Sydney Children's Hospital Stage 1 and Children's Comprehensive Cancer Centre

State Significant Development Architectural Report _Addendum
SSD Application - 10831778

SCH-AR-RT-DA058A[A]

September 2021

1:1500

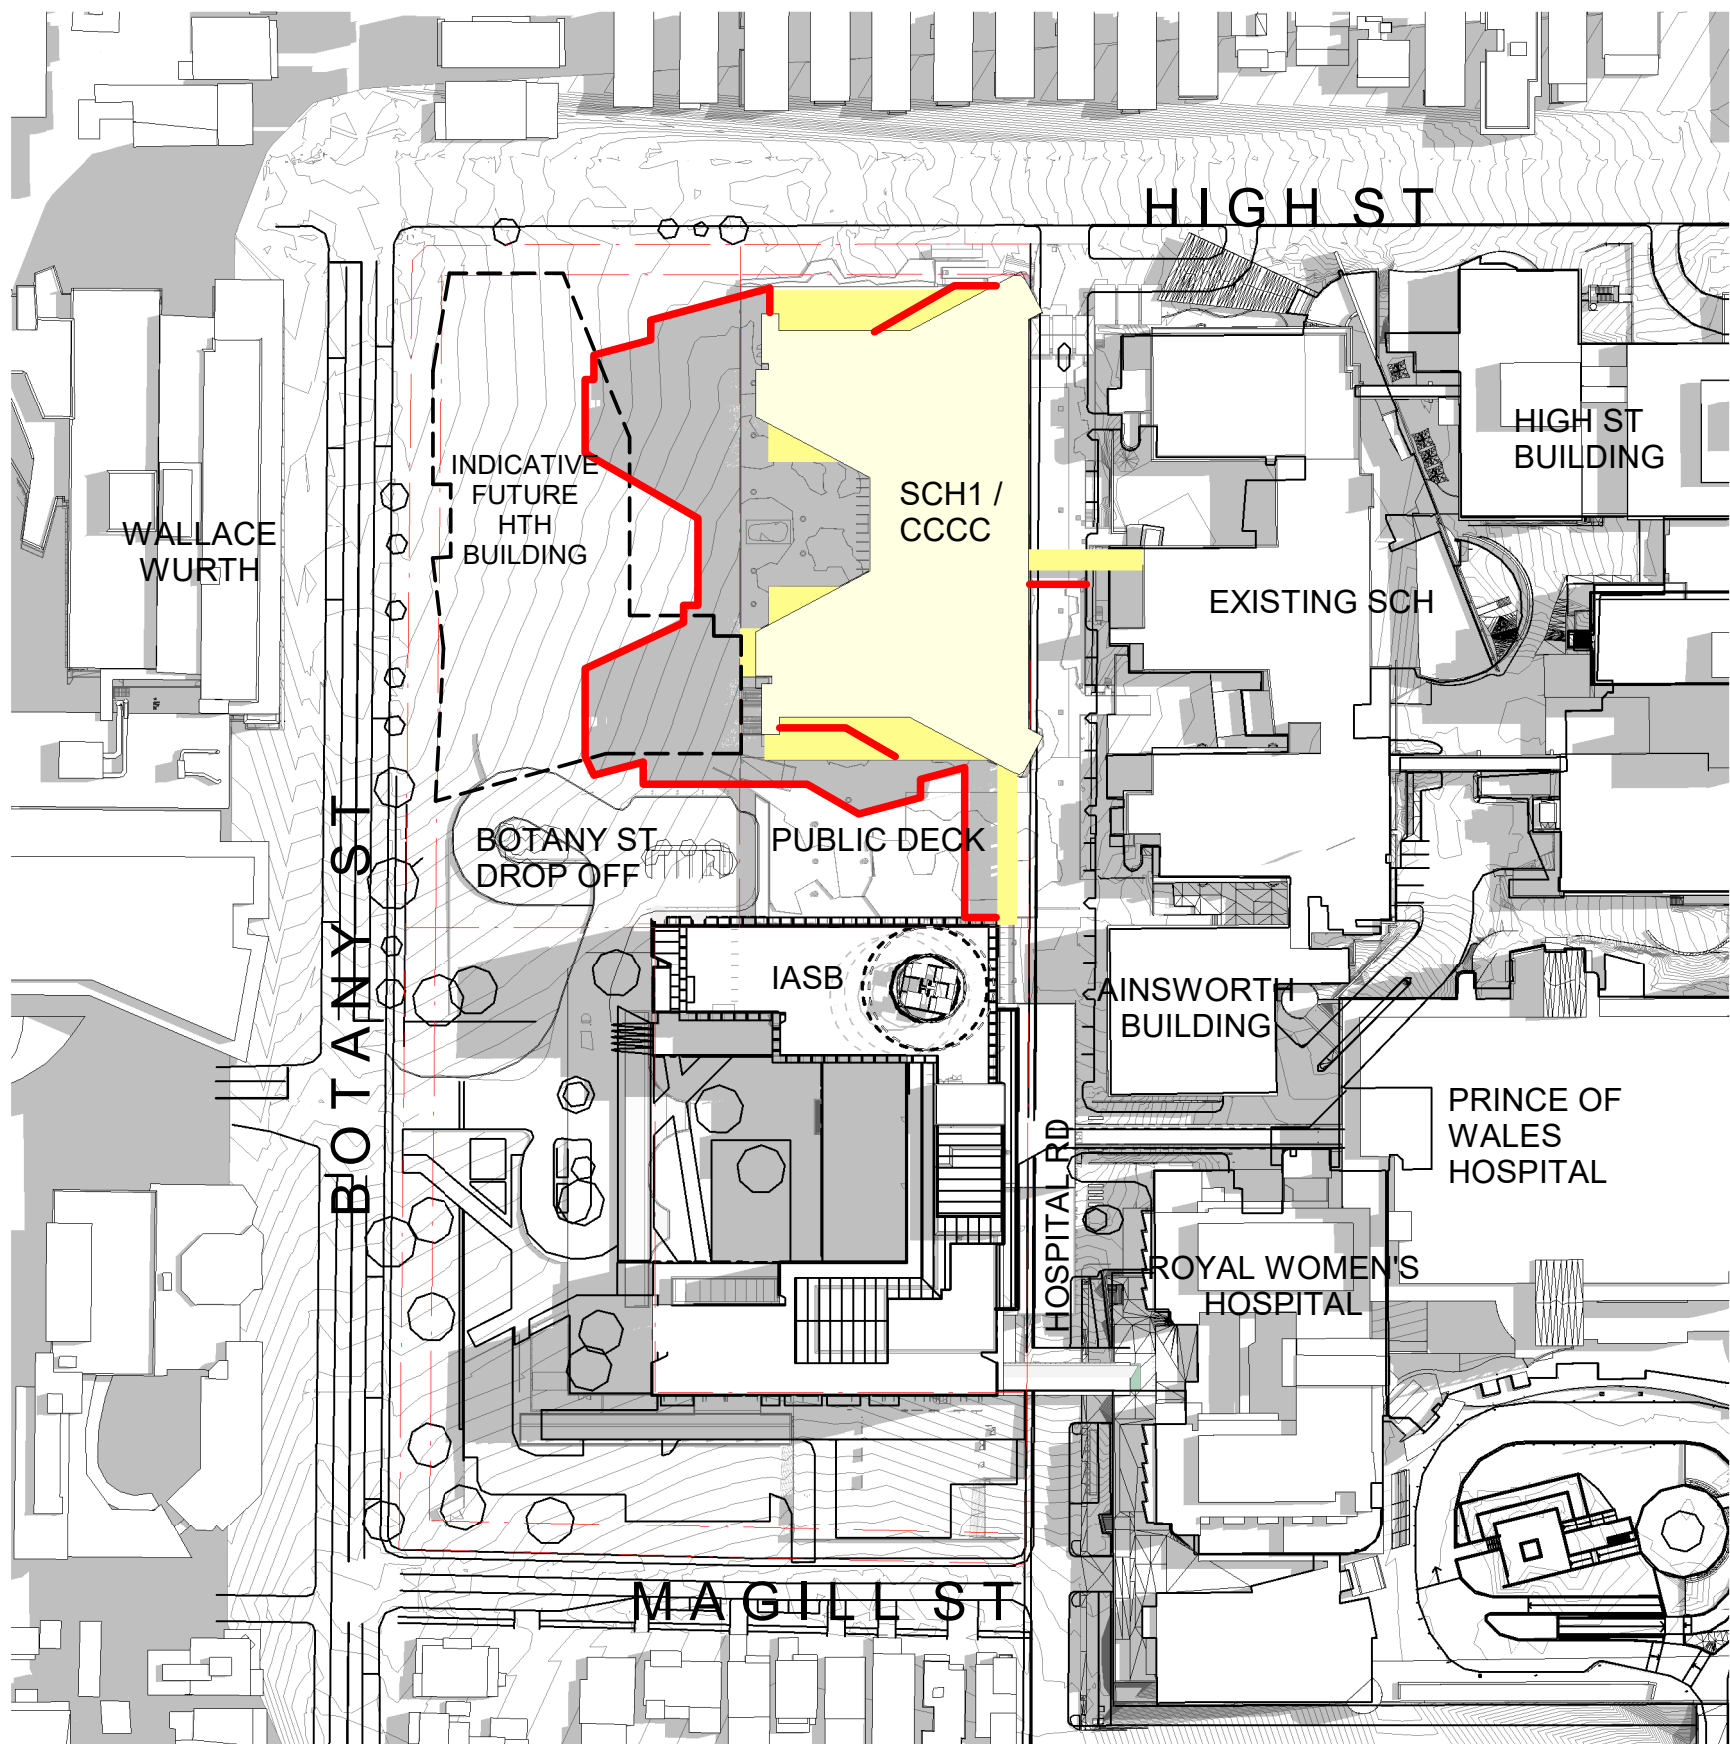
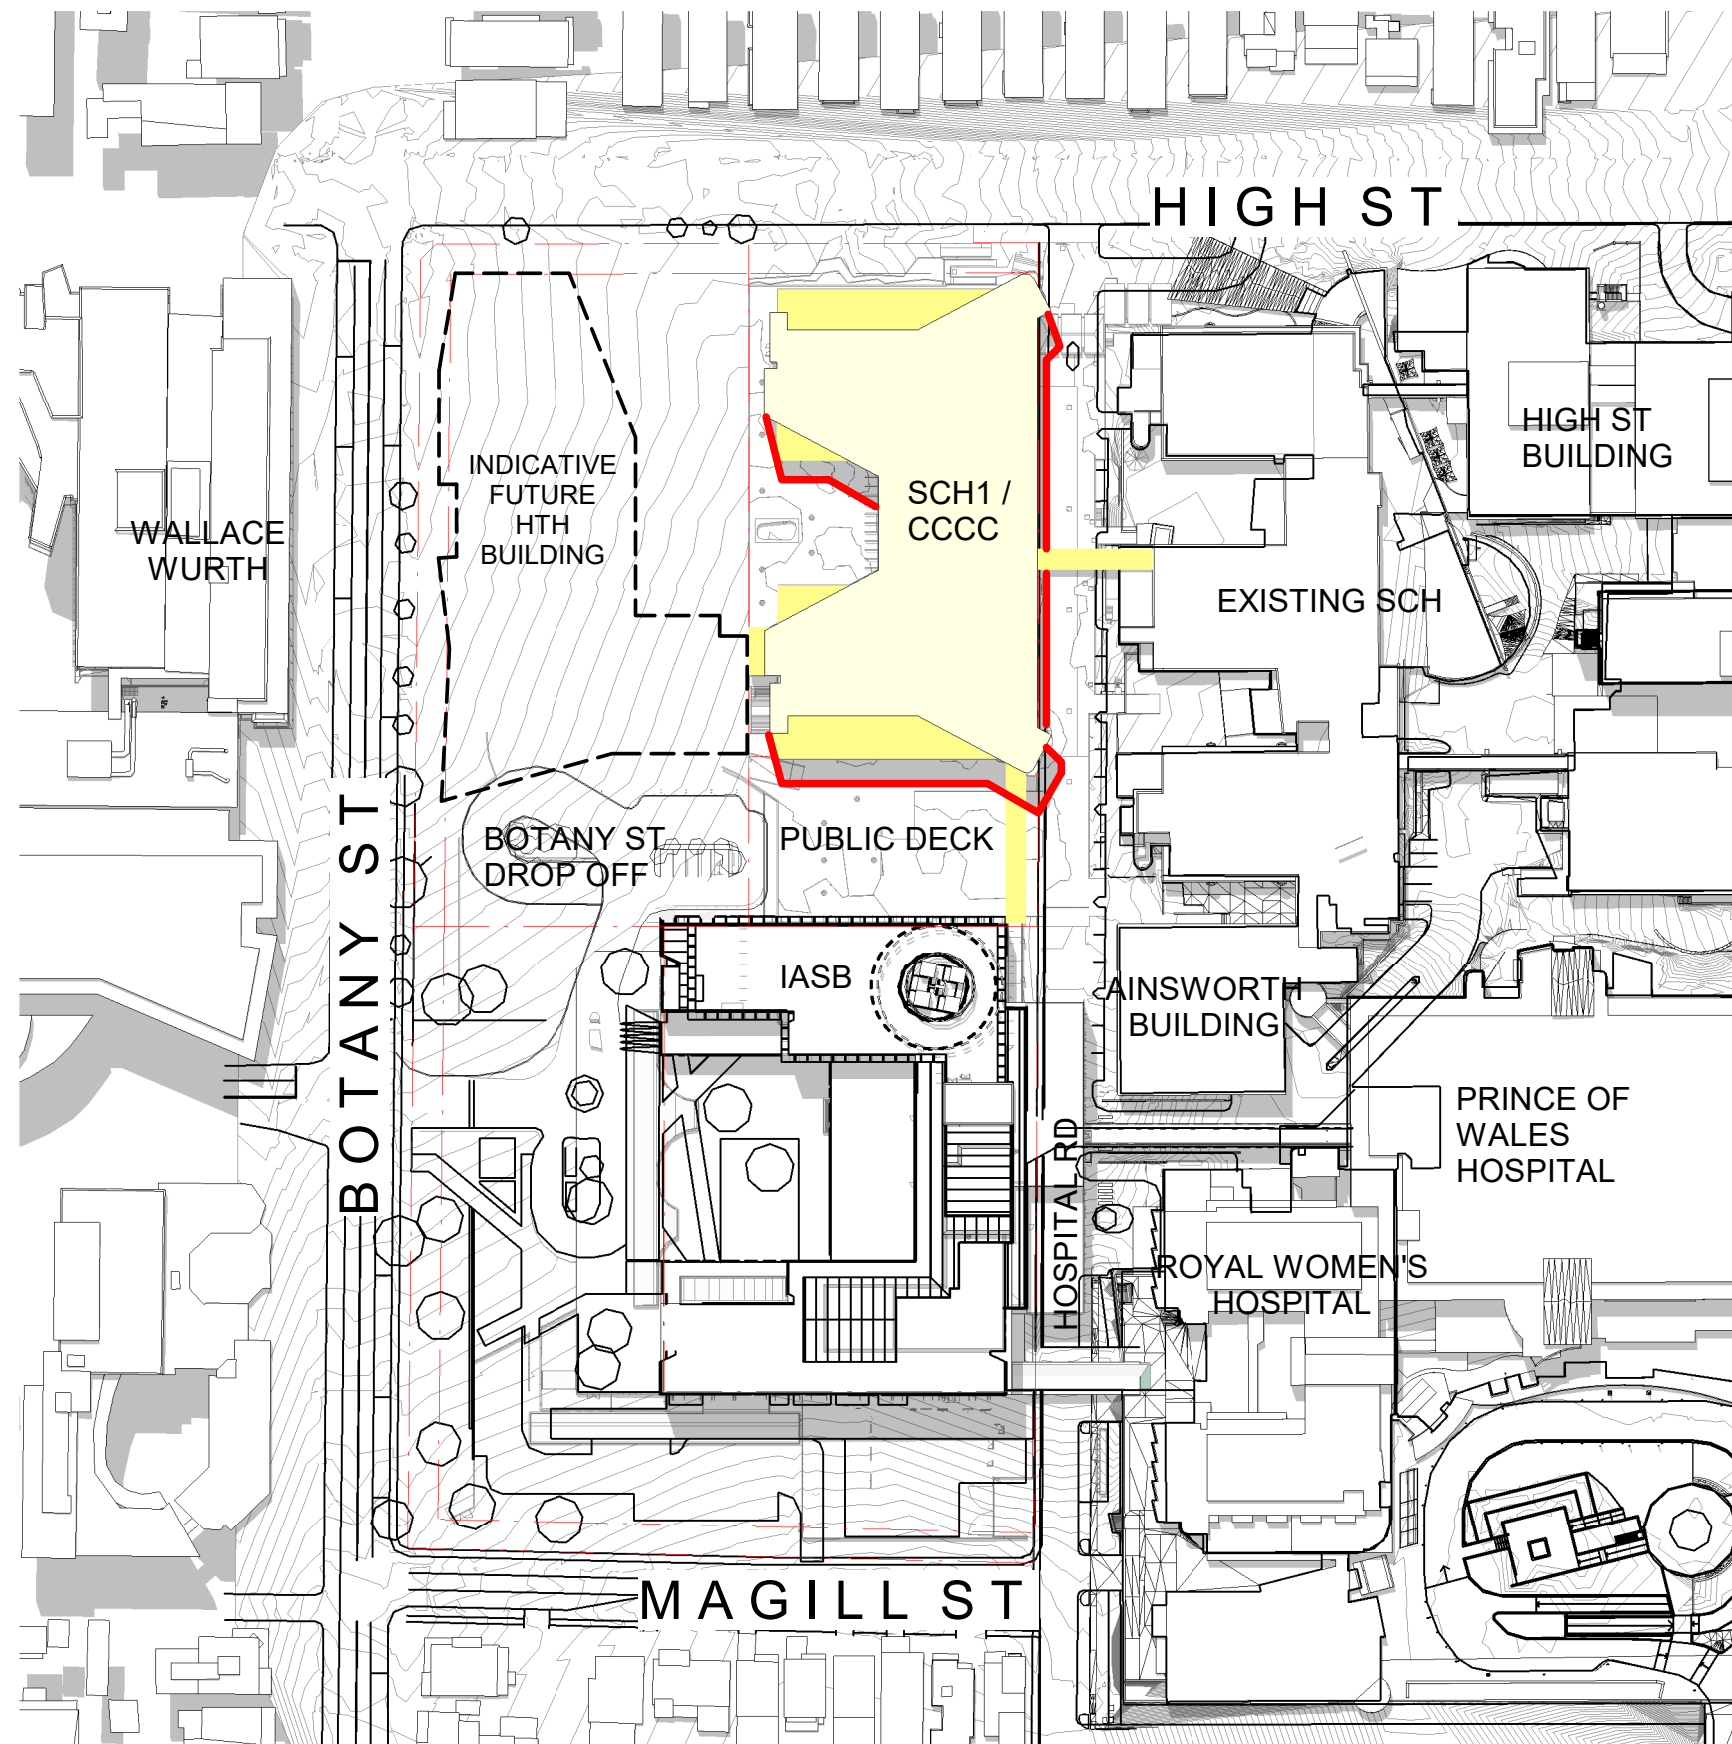
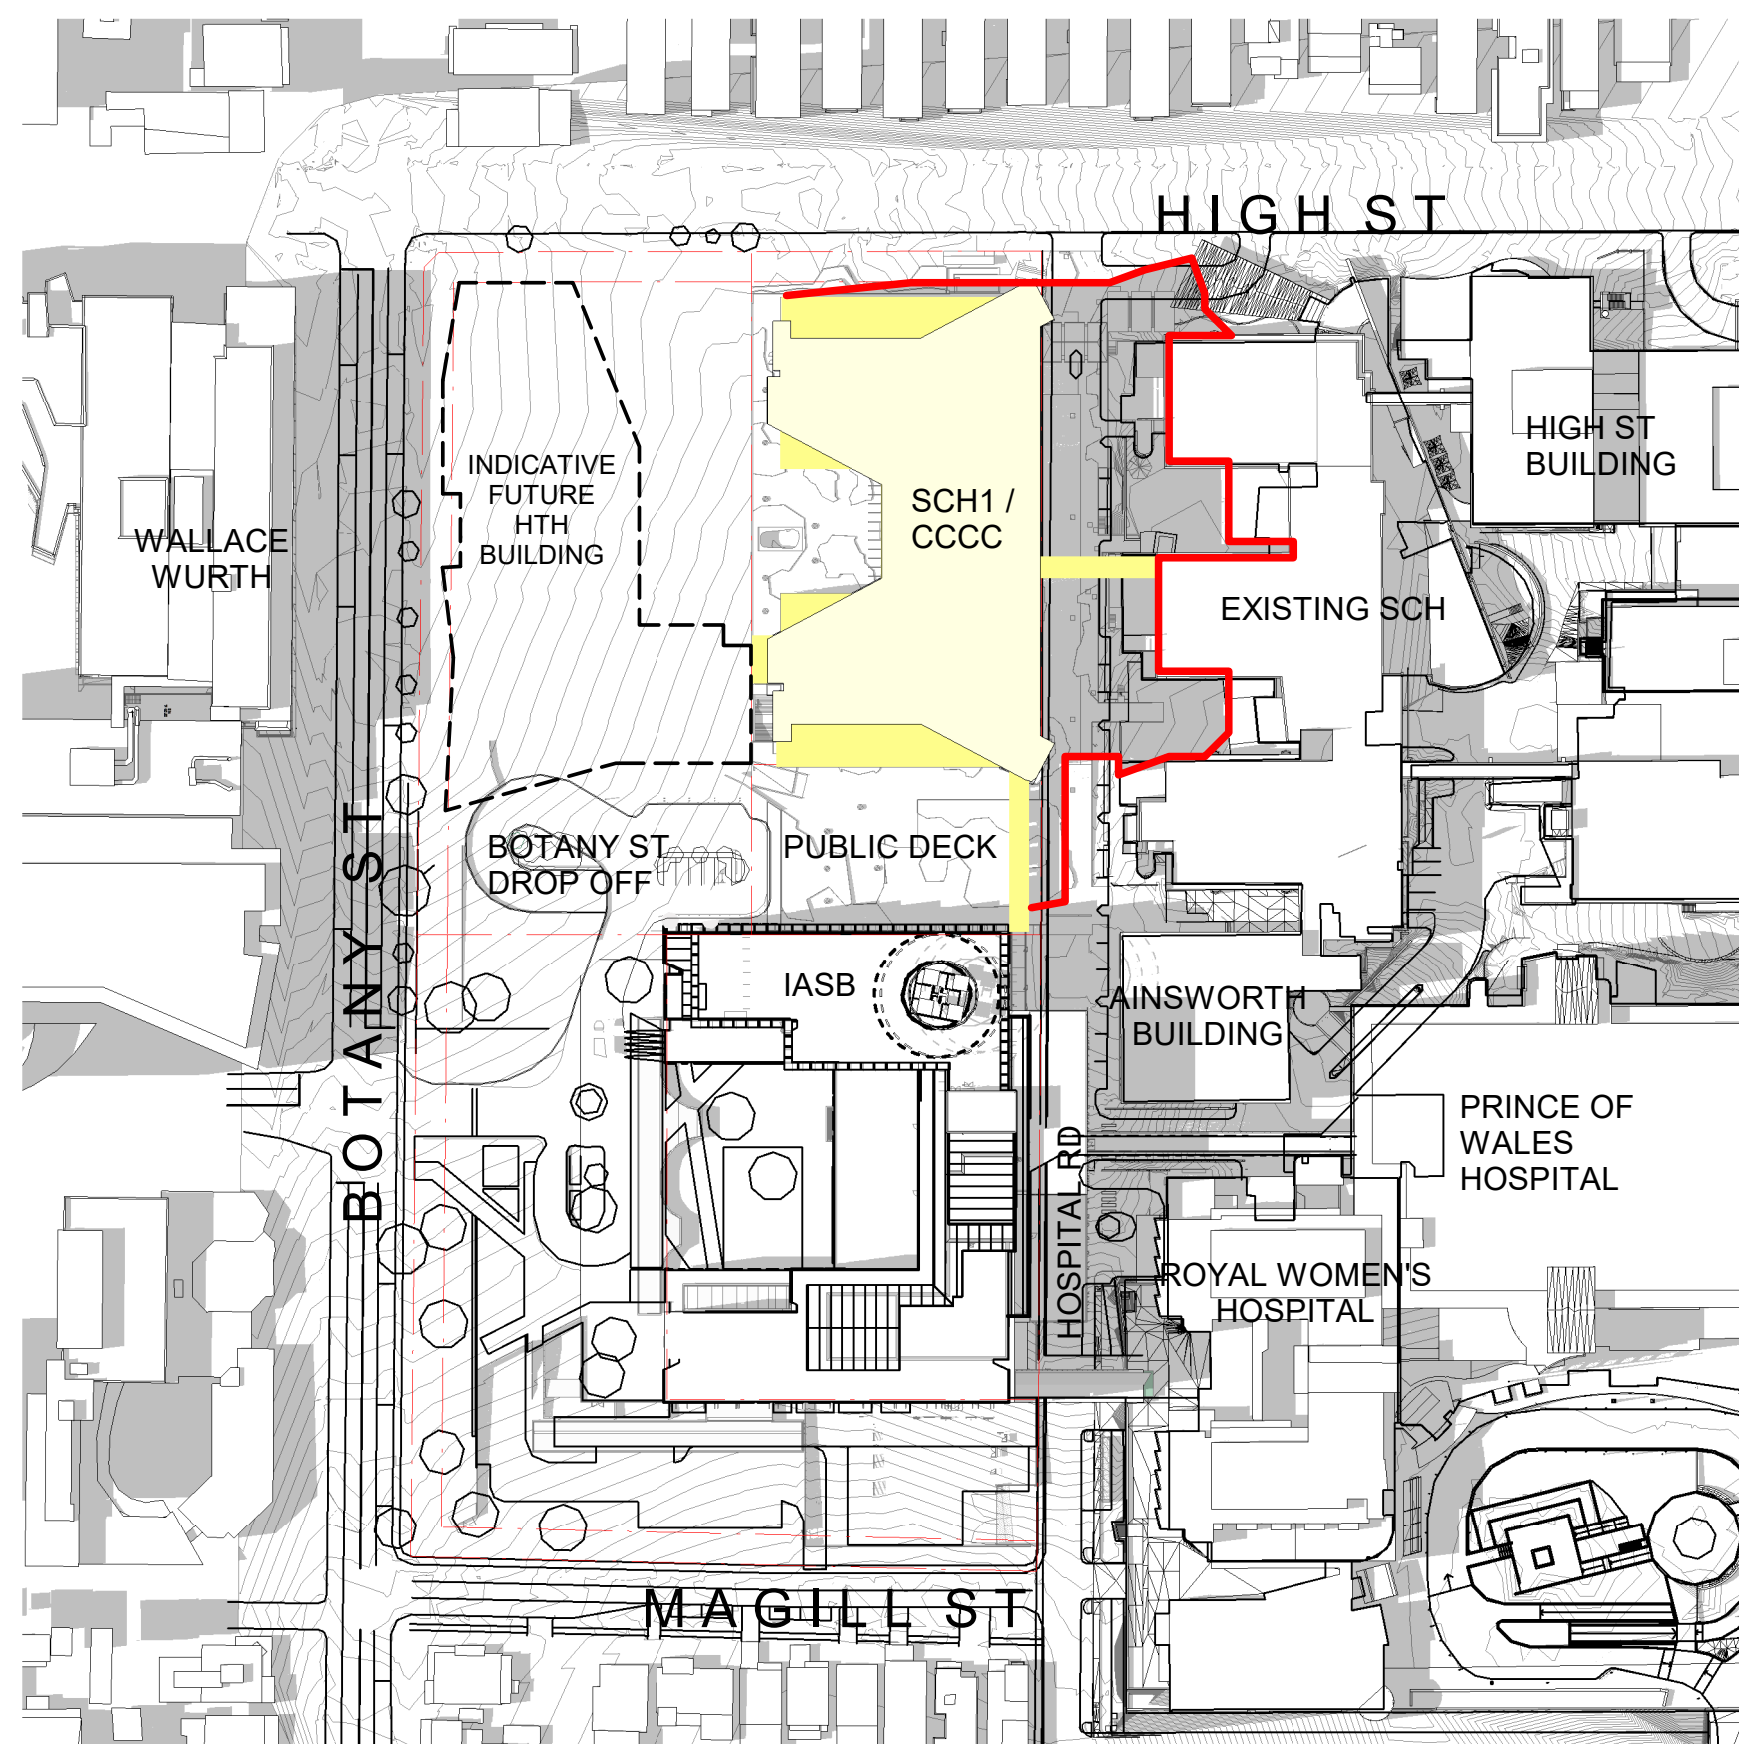
<p>A further concern is the significant overshadowing of this arrival area throughout the year and particularly in winter. This contrasts with the current sunny north facing High Street entry. Additional information and detailing is required to demonstrate how this waiting space will be treated to provide a warm and inviting arrival experience and safe waiting area for parents and children, given the constraints outlined above.</p>	<p>Functional adjacencies have required the Emergency Department to be located on Level B1, with access provided via the Botany Street entry.</p> <p>Competing requirements for access to not only the Emergency Department, but also the IASB and the HTH have all been considered in the design of this shared vehicular entry and drop off point.</p> <p>The design of the Emergency Department itself is based on required functional adjacencies and workflows and ensures a clear arrival point and clear and direct access to Triage as a key functional priority.</p> <p>BLP have provided updated additional renders demonstrating clear access and amenity to the Emergency Department reception. Refer to Appendix A of this report</p> <p>Internally, opportunities for integration of public art will be investigated.</p> <p>Refer to architectural drawings, for additional internal detail of Emergency Department.</p> <p>Refer to architectural drawings SCH1-AR-DG-SDD040, SCH1-AR-DG-SDD041, SCH1-AR-DG-SDD042 and SCH1-AR-DG-SDD043.</p>
